MDT-PUDSP21010-R2-PDR.pdf Markup Summary

EX-1

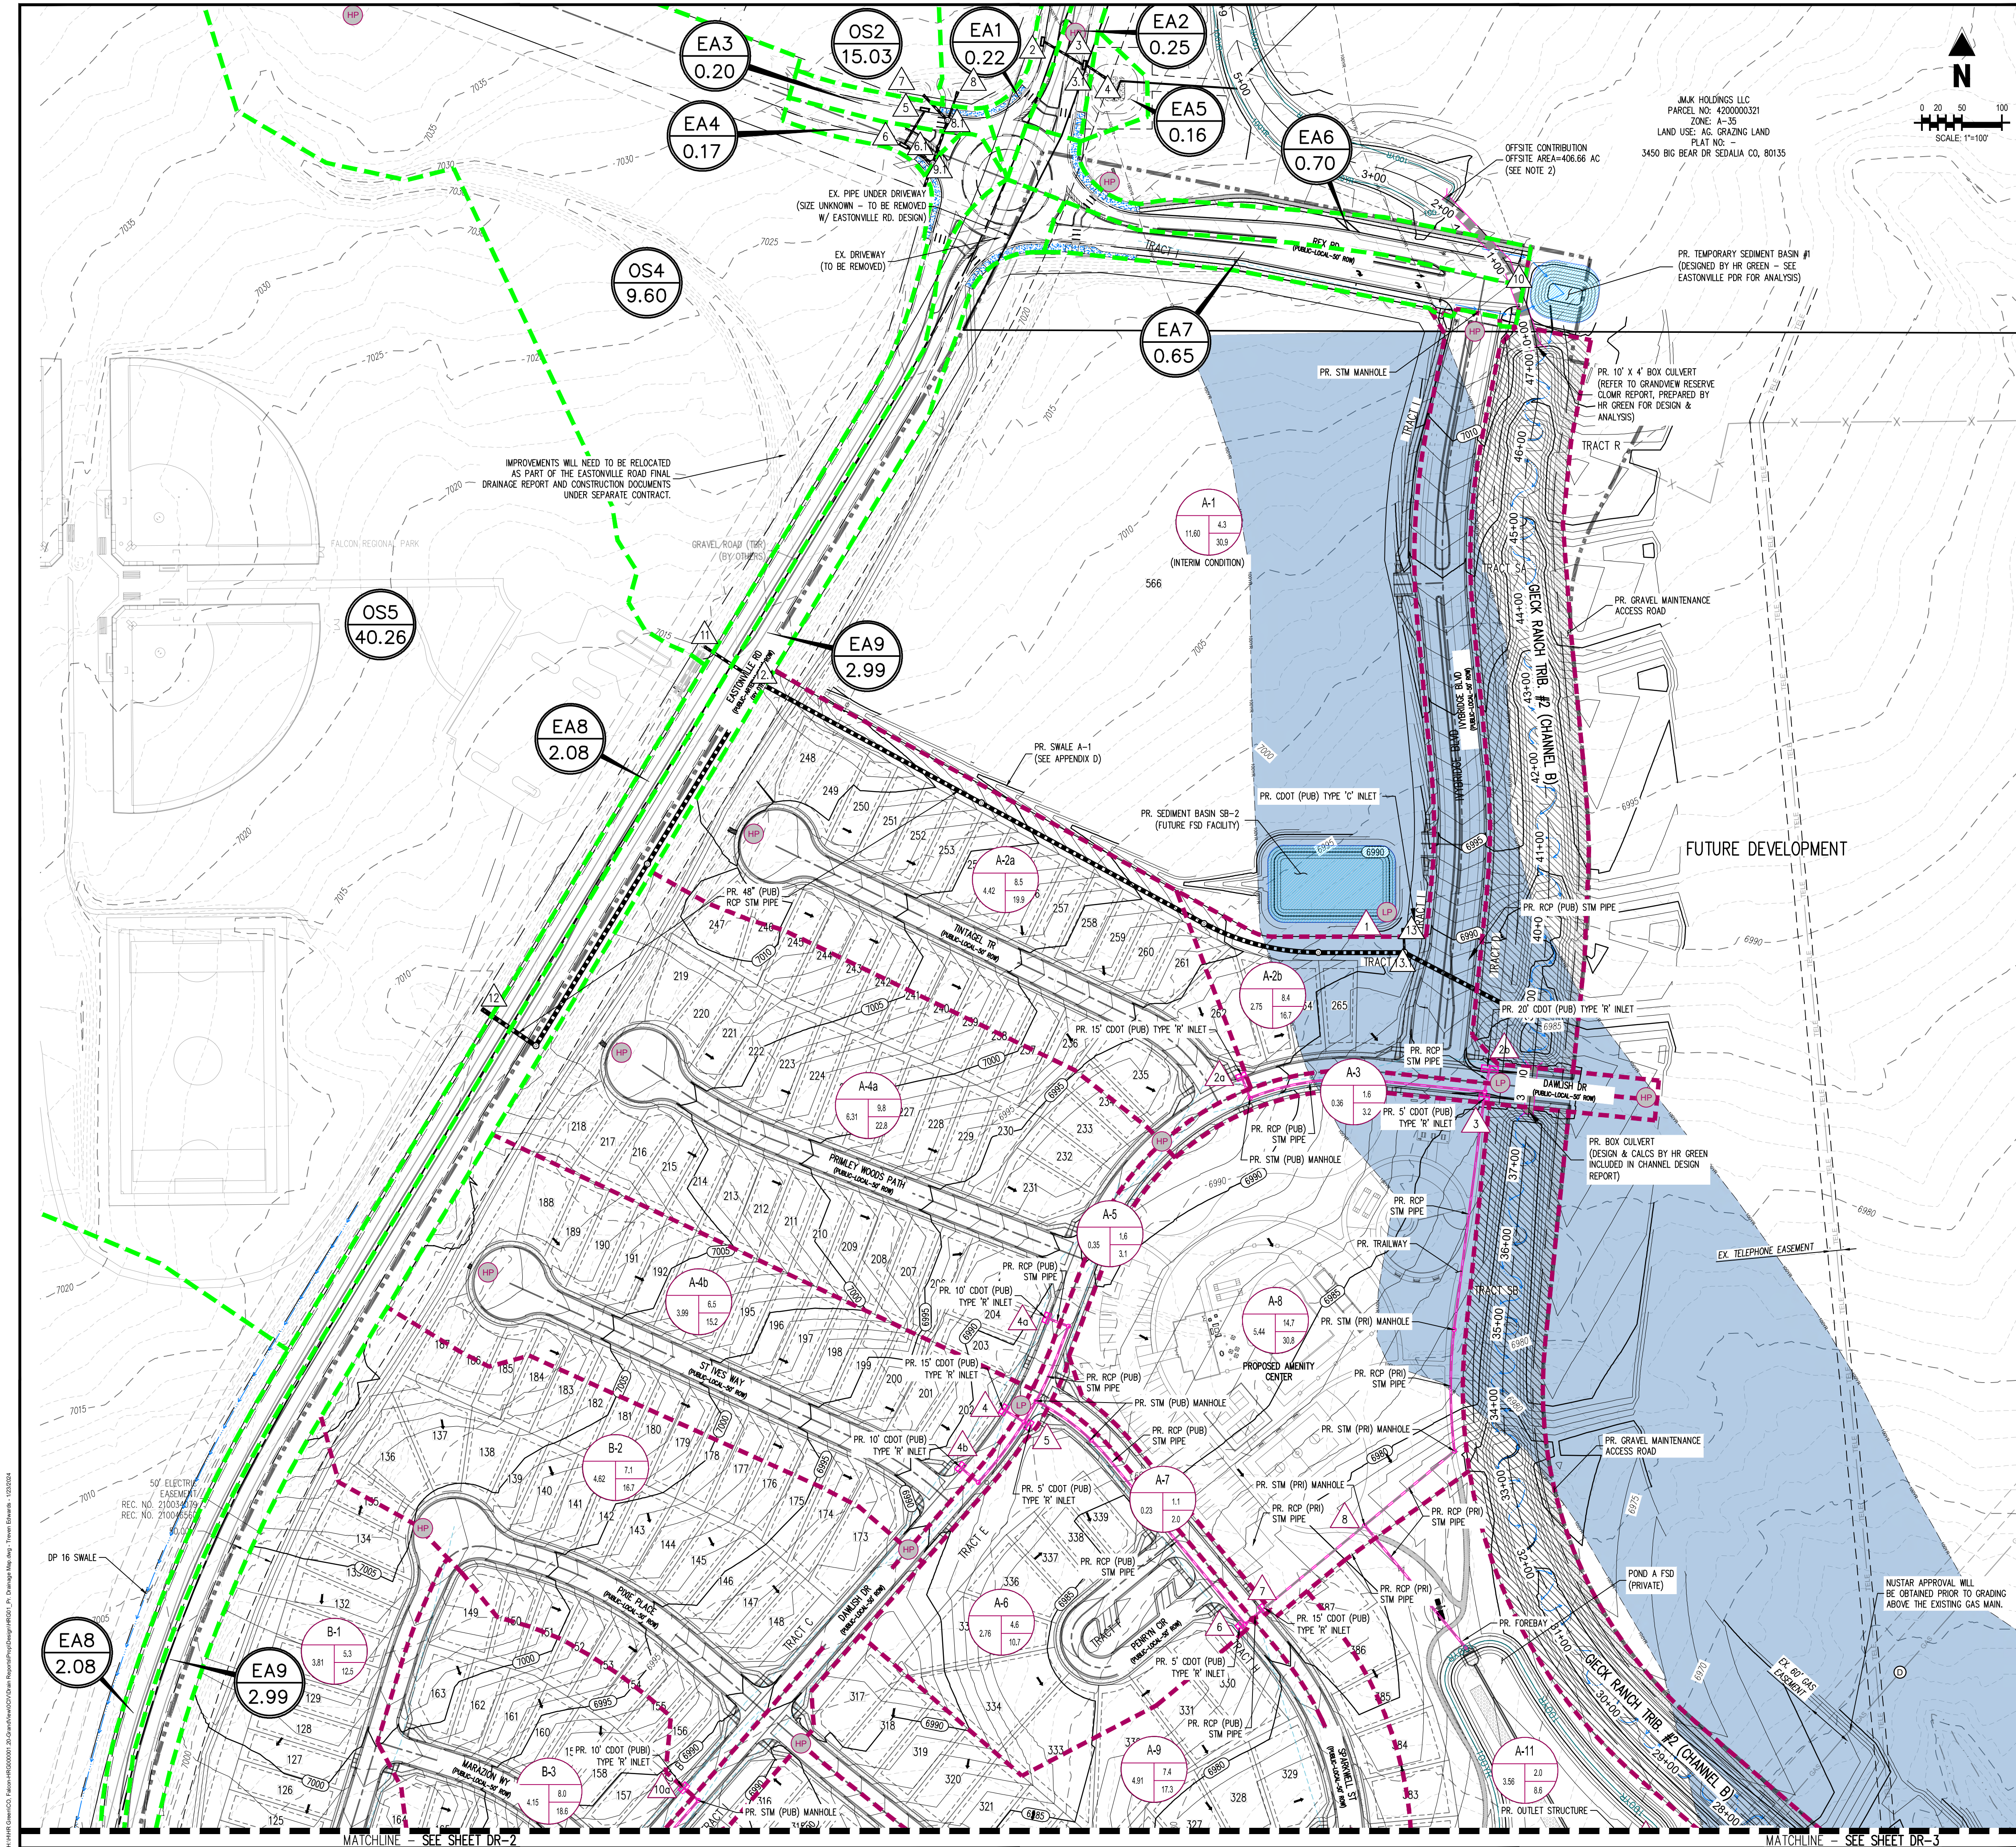
There should be at least 7 onsite and offsite existing basins - break these up as appropriate. See Existing Condition plan redlines.

This area (EX-3 and a large part of what's shown as EX-1) historically drains to the east - the increased flow in this channel requires downstream analysis.

Provide for all existing basins

the computed value needs to be used for existing conditions (the area isn't urbanized yet)

DR-1
Sheet 1 of 3

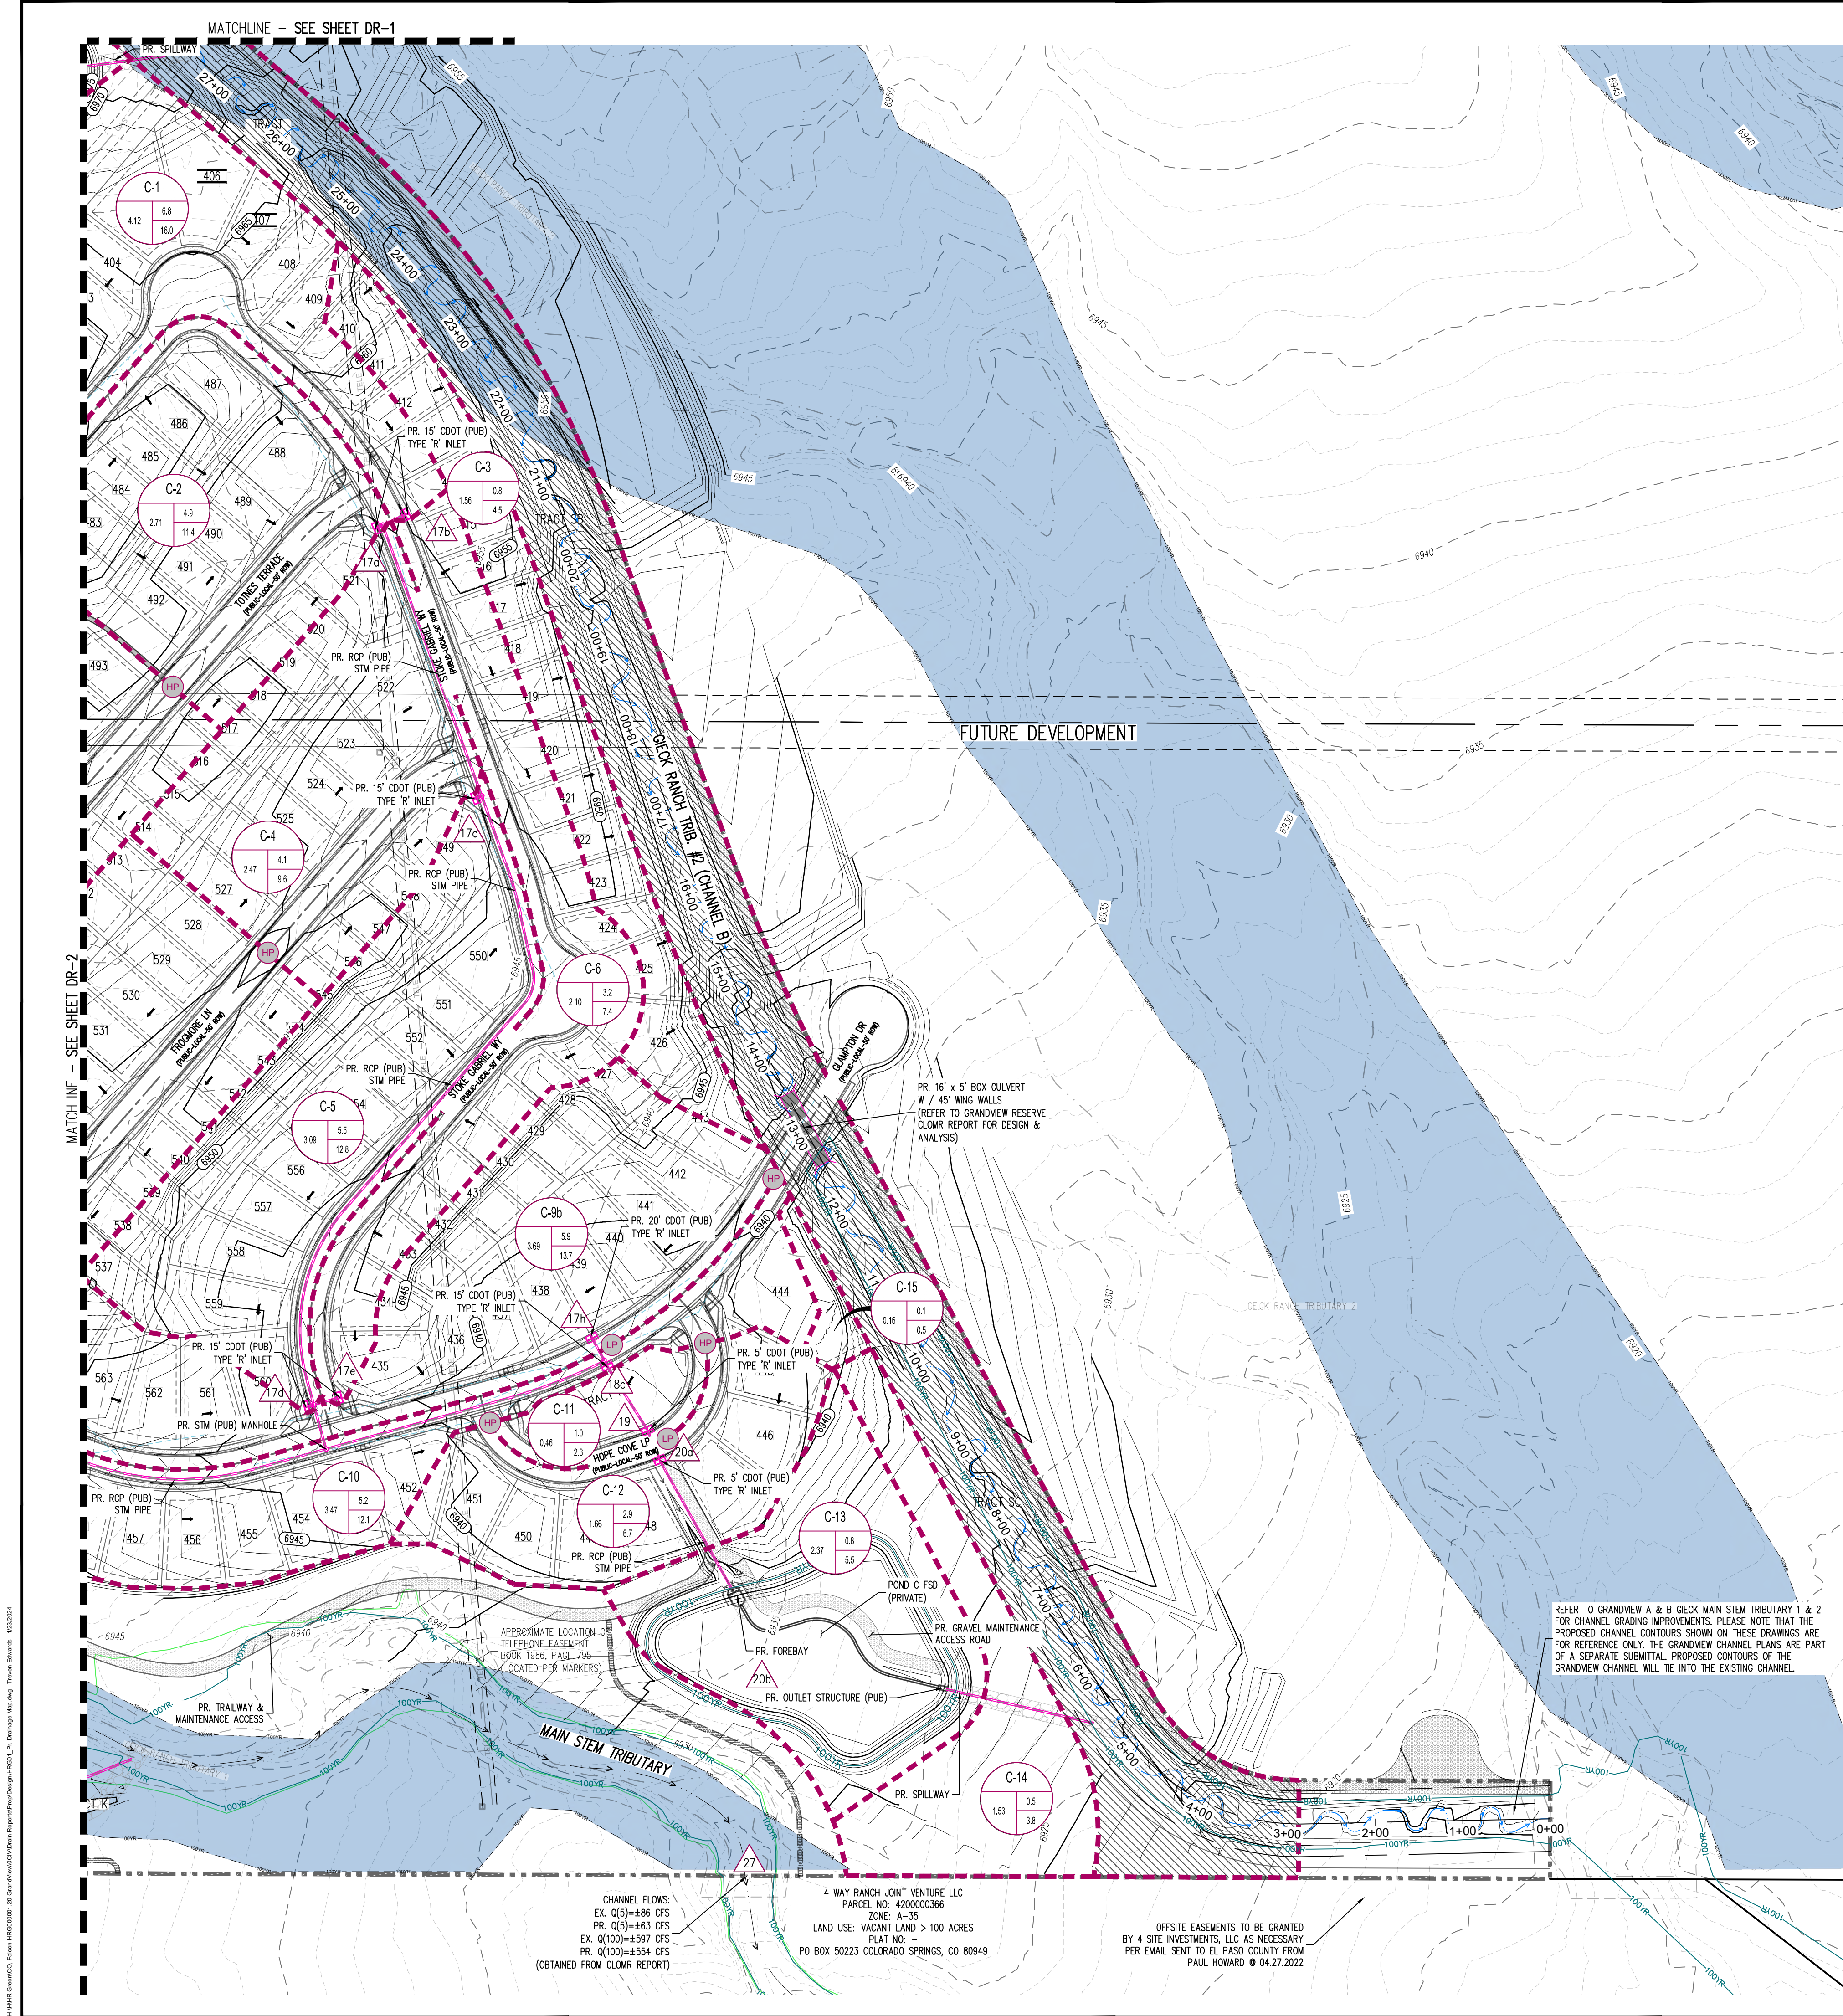
Label drainageways MS, MST, EFT etc. consistent with MDDP.
